From: sibford.gower.pc@thesibfords.org.uk <sibford.gower.pc@thesibfords.org.uk>
Sent: 08 June 2021 14:15
To: Matthew Chadwick <Matthew.Chadwick@Cherwell-DC.gov.uk>
Cc: Councillor George Reynolds <George.Reynolds@Cherwell-DC.gov.uk>; Councillor Phil Chapman <CouncillorPhil.Chapman@Cherwell-DC.gov.uk>; Planning <Planning@Cherwell-DC.gov.uk>; Roger Mallows <cllr.roger.mallows@thesibfords.org.uk>; 'Cllr David Allen' <cllr.david.allen@thesibfords.org.uk>
Subject: FW: 21/01437/F
Importance: High

Sibford Gower Parish Council **OBJECTS** to this application.

However, there is a specific concern relevant to this prominent village location, bounded to the west by the conservation area, namely:

drwg no 253\_04\_301 rev P4  
title Proposed Elevations II  
scale 1:100 @ A3

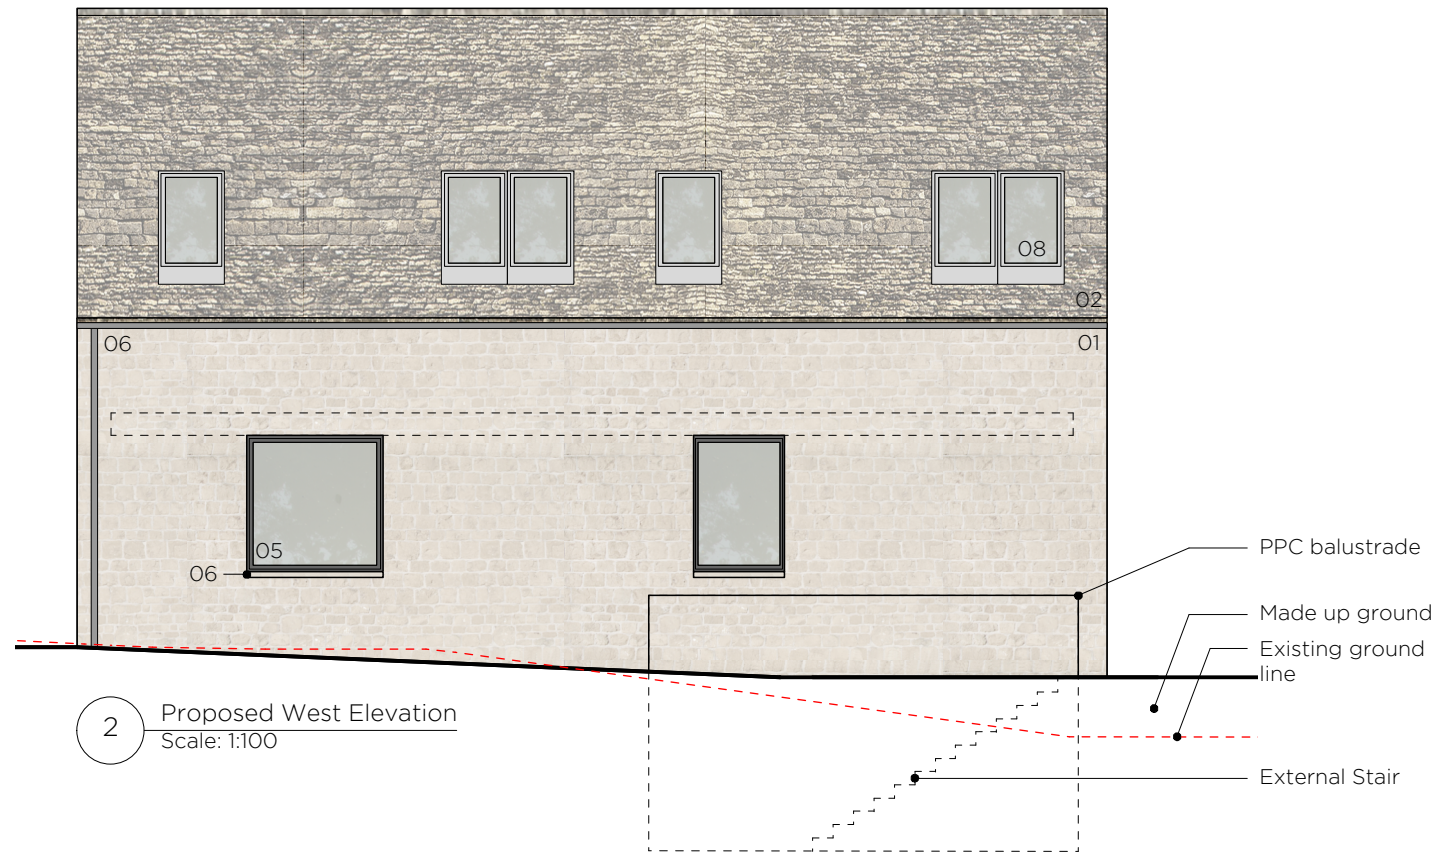
The overall impact of the exterior finish to the proposed large dwelling (high quality stone with semi-translucent limewash finish / artificial stone slates) is considered highly inappropriate as it will generate a large physical mass which will both intrude and dominate the surrounding area, failing to blend harmoniously with the nature and character of the location. We would seek a visual appearance utilising a blend of local materials and finishes which will both enhance and conserve the essential character and nature of this prominent village location.

- prior approval of a sample panel to determine the precise nature of exterior finish is identified as a critical element
- no specific colouring is identified for the aluminium clad window frames
- no location is offered for the proposed air source heat pump or solar panels
- the subsequent location for any future garage/outside storage provision should be addressed through appropriate planning measures
